TR010064: Application by National Highways for the M60/M62/M66 Simister Island Interchange Project

The Examining Authority's Written Questions and requests for further information

Issued on 17 December 2024

Reproduced by permission of Ordnance Survey on behalf of HMSO. © Crown copyright and database right 2024. All rights reserved. Ordnance Survey Licence number 100030649.

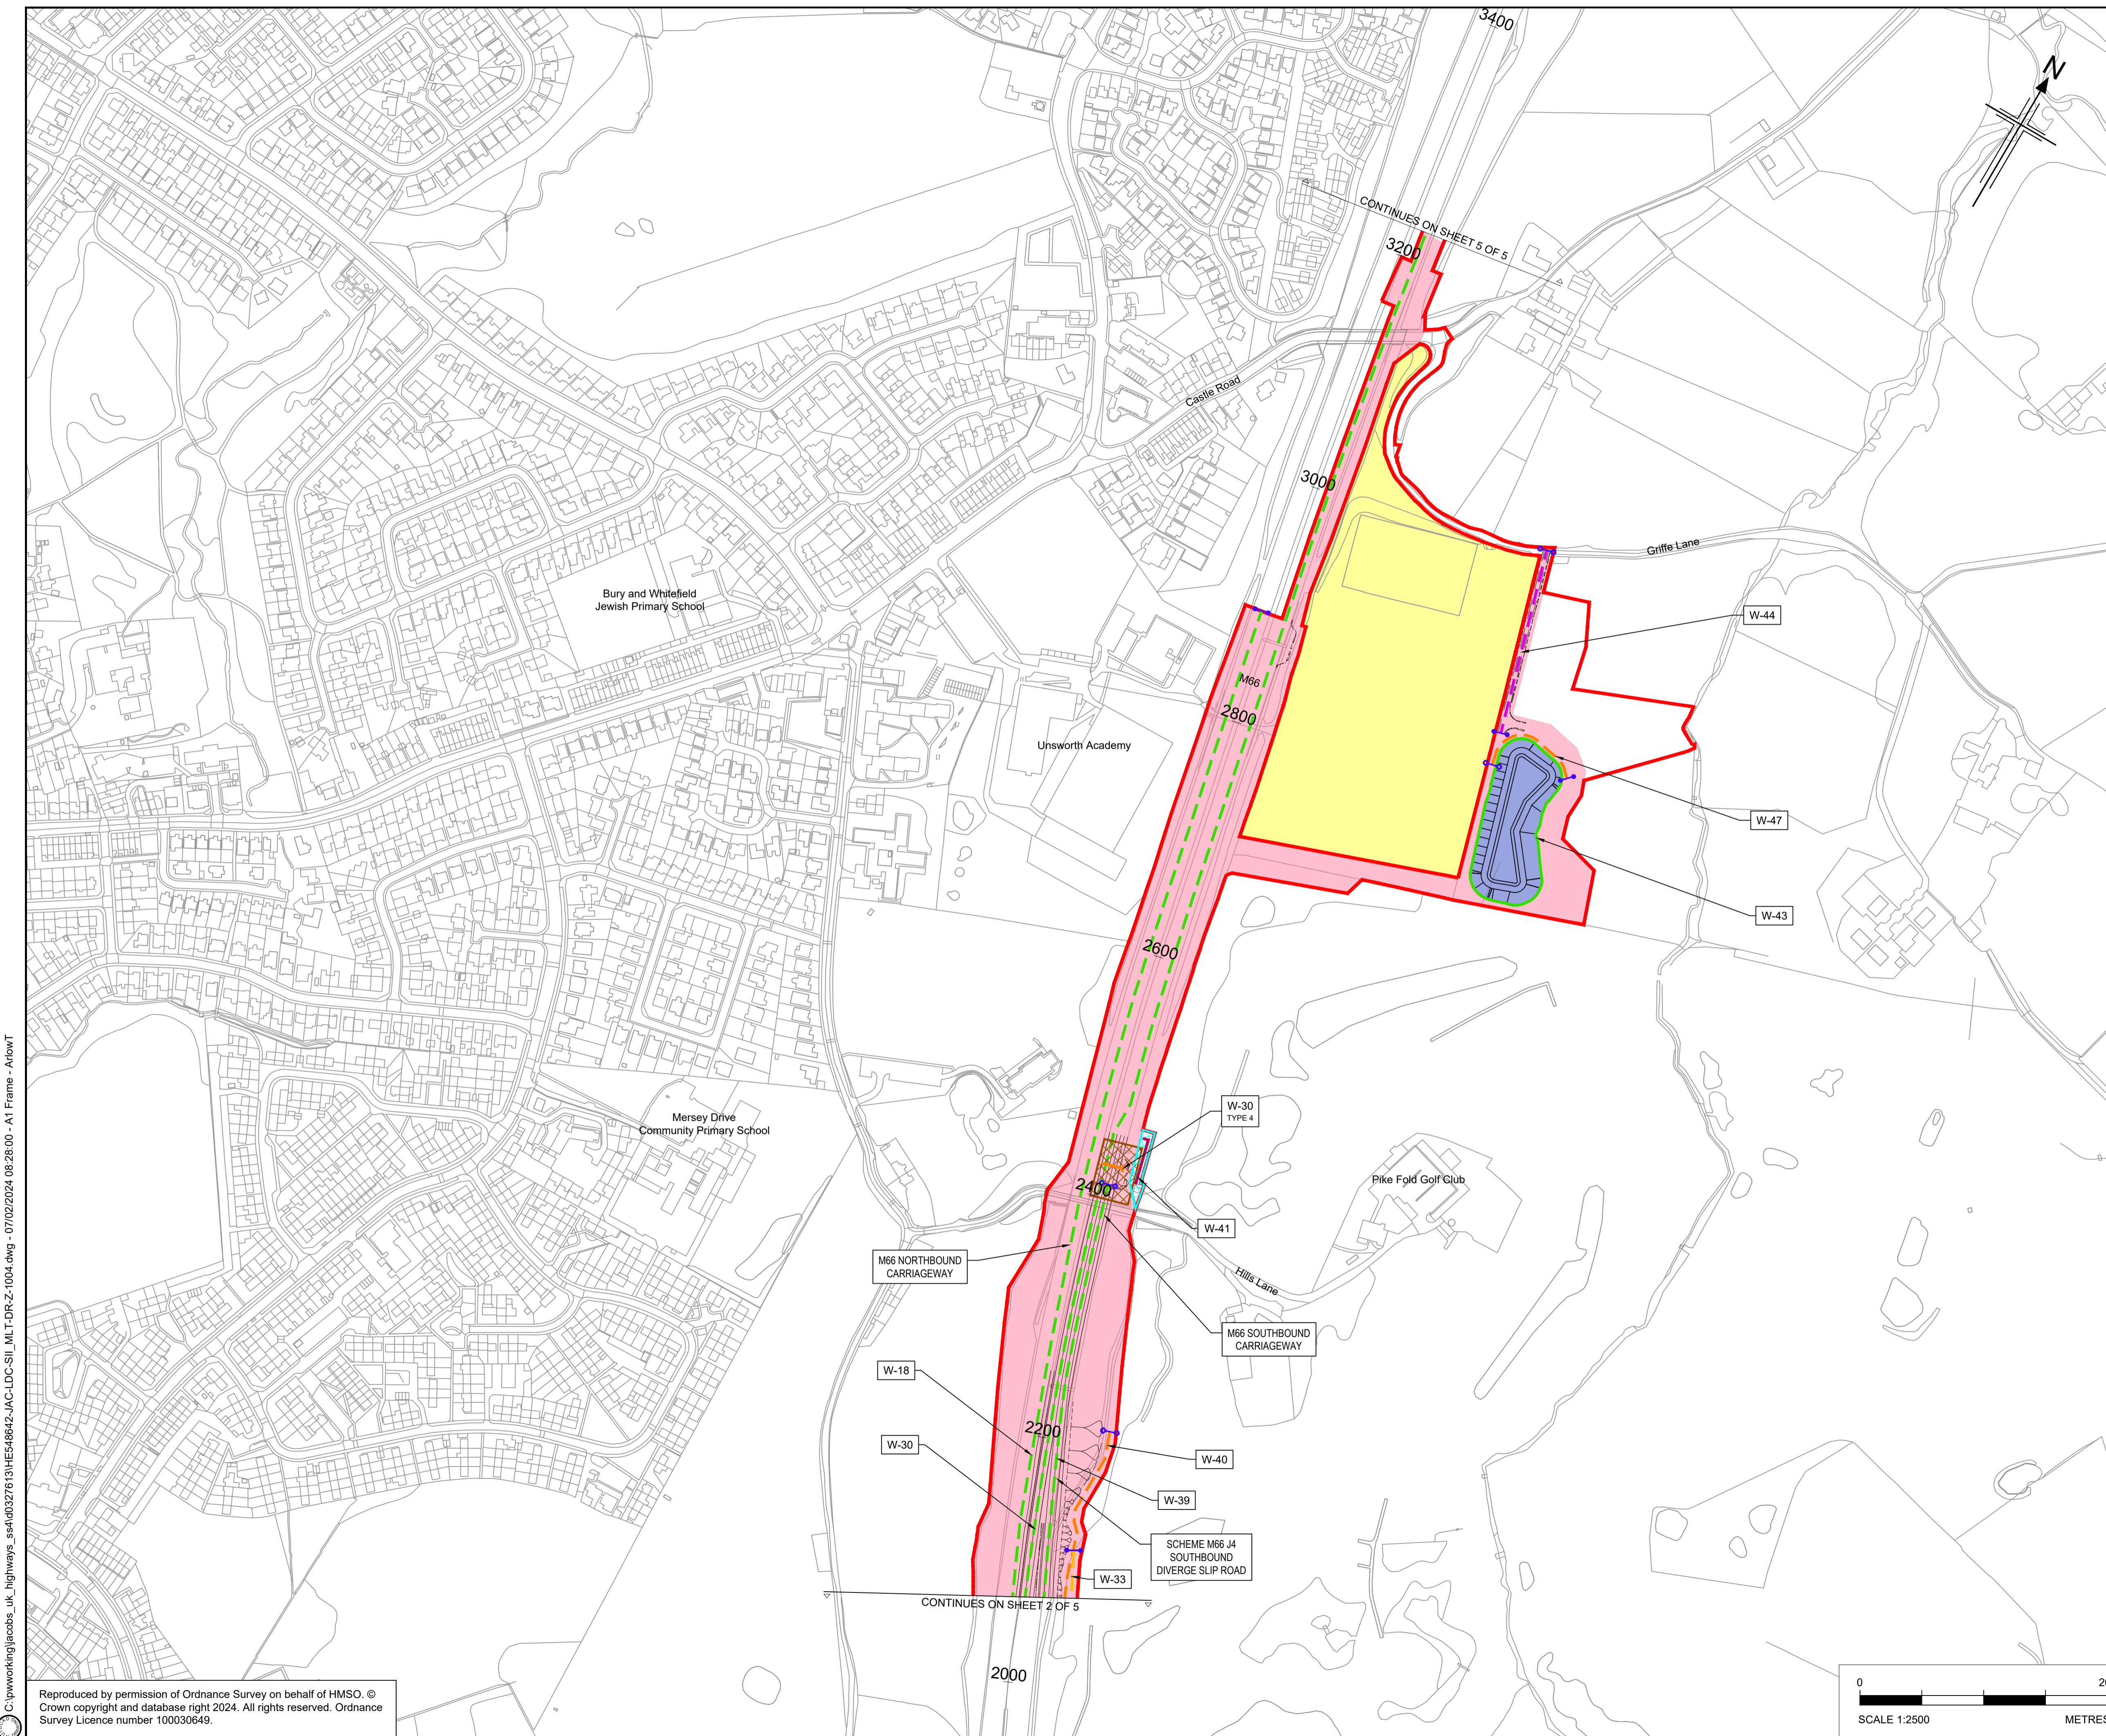
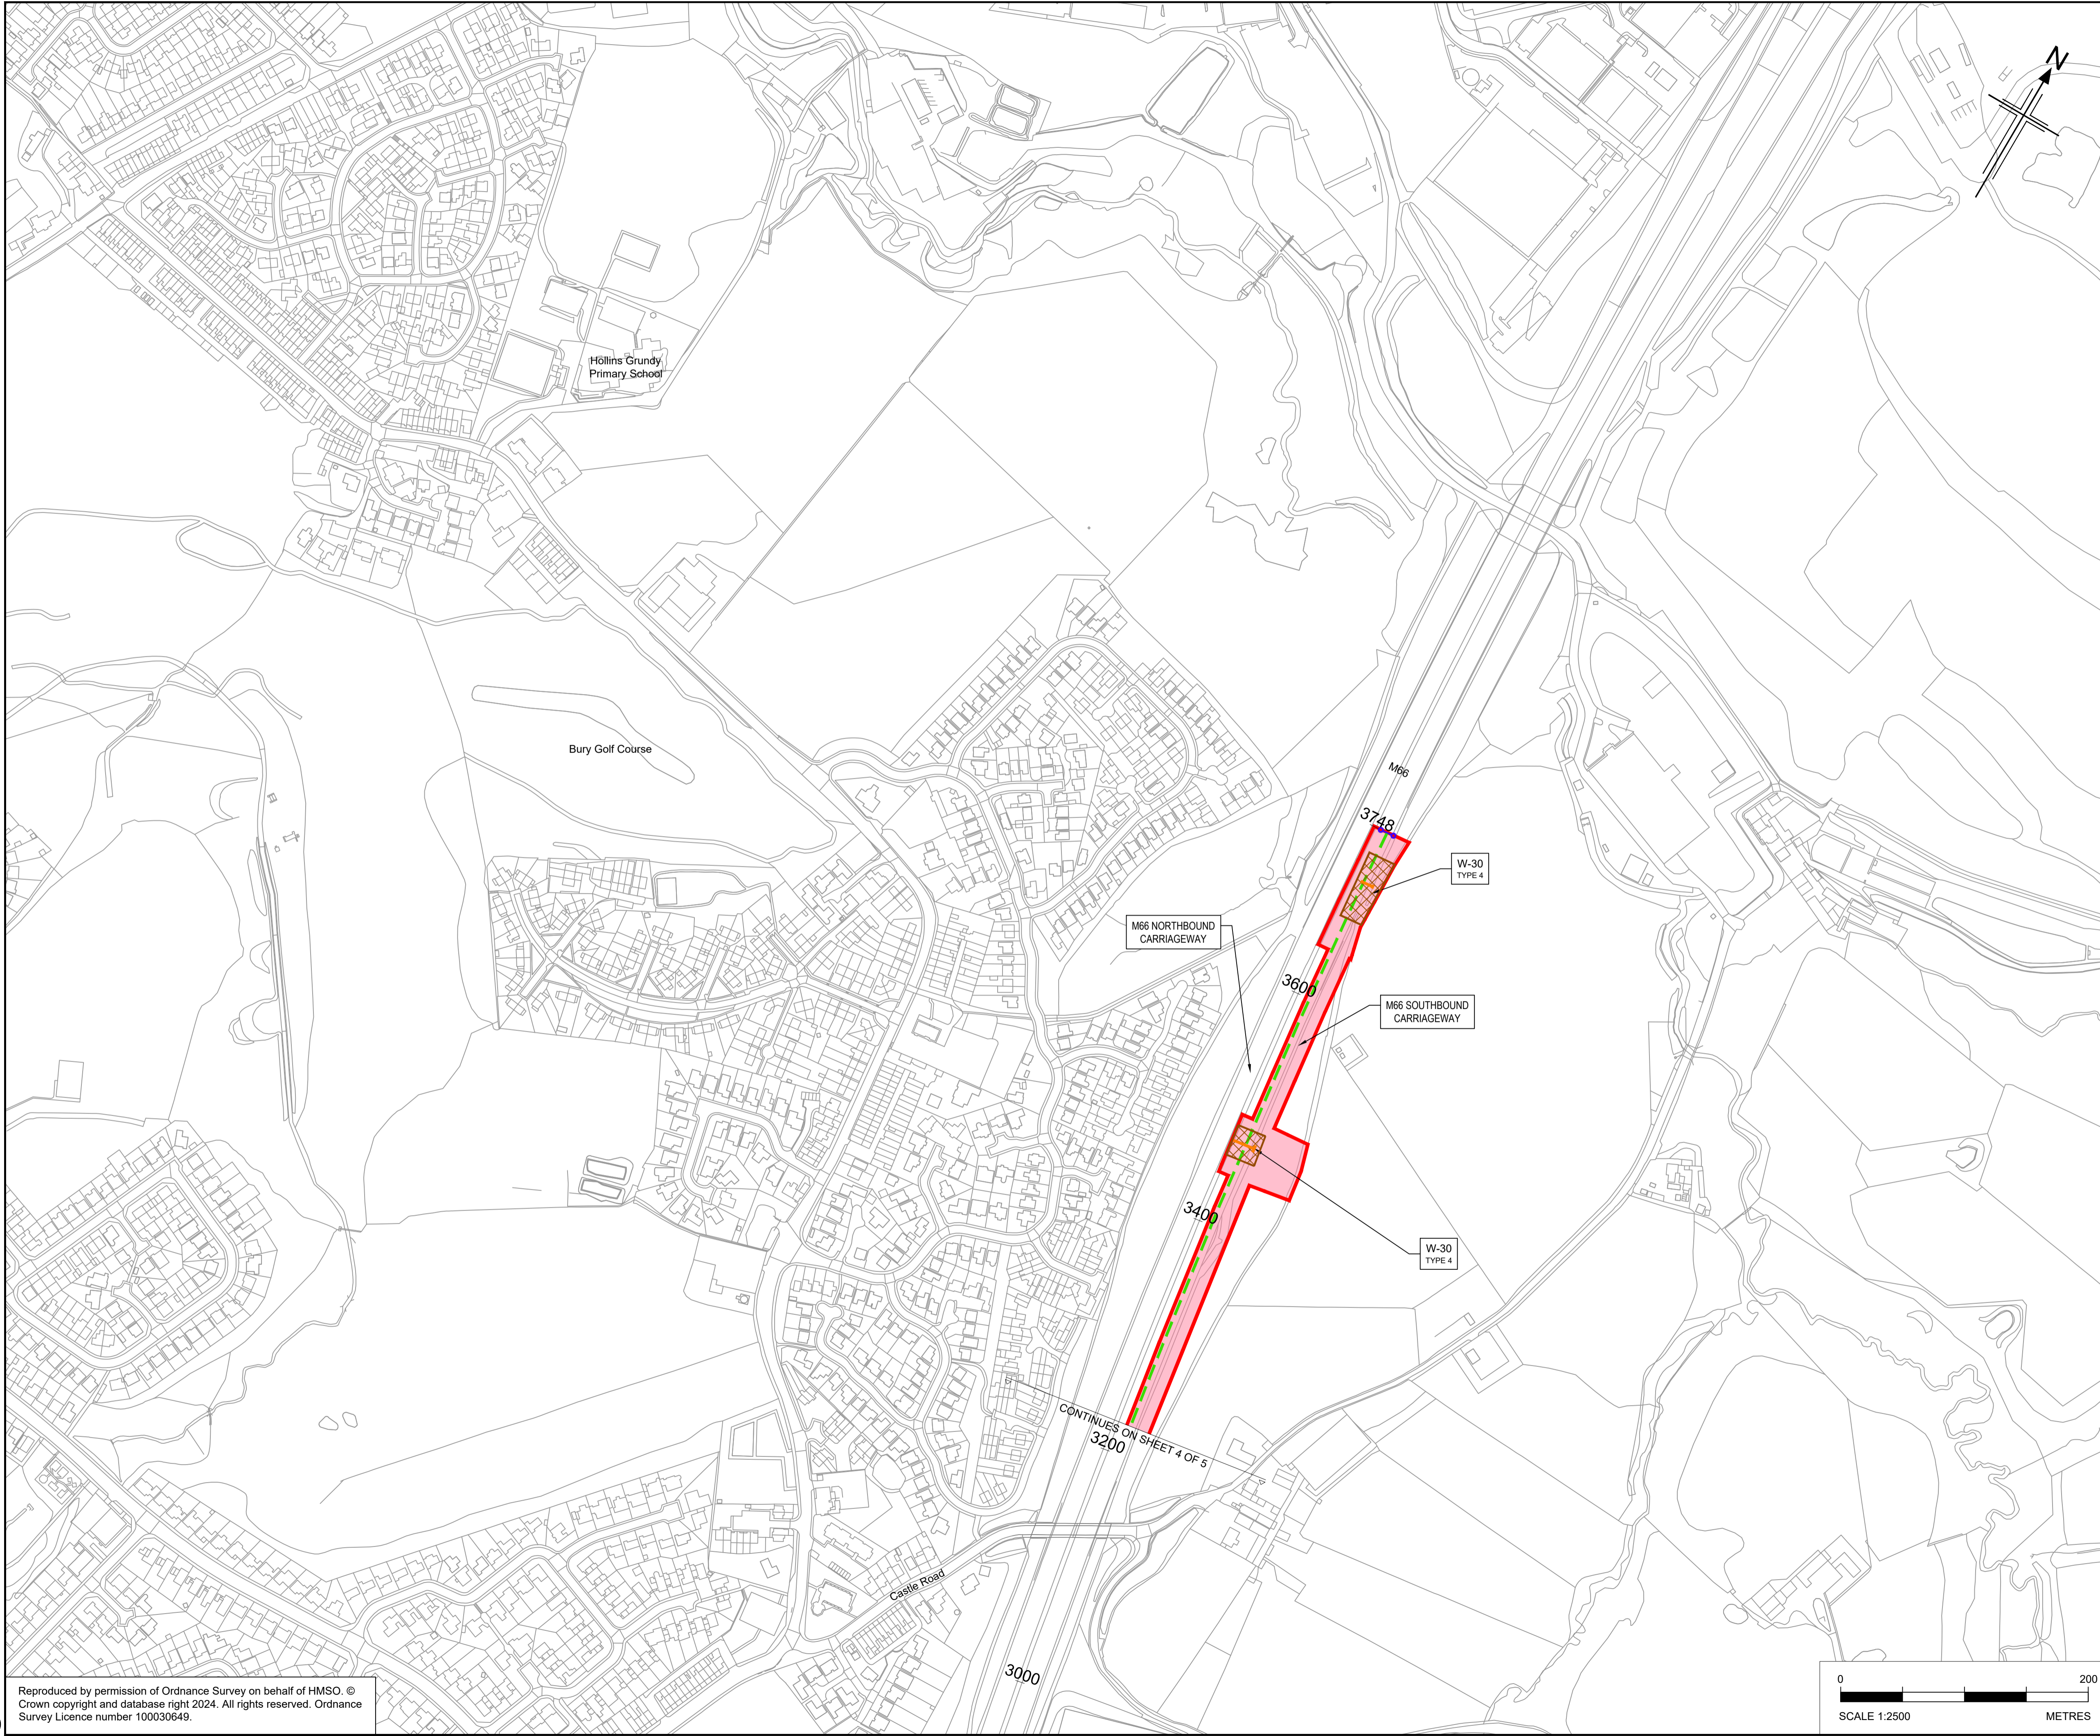
| CA.2.5 | Applicant | <p>Plot 1/1a</p> <p>In CAH1 the applicant explained that the whole of Plot 1/1a was within the ‘limits of highway deviation’ as indicated by pink shading on the Works Plans [AS-006]. The termination of the linear works (indicated by dumbbells) is shown on the Works Plans to be at the very eastern extent of Plot 1/1a. Explain why the entirety of Plot 1/1a is required for permanent acquisition, which includes carriageway beyond the termination of the linear works, and also land to the north and south of the M60 outside the existing slip roads and verge.</p> |
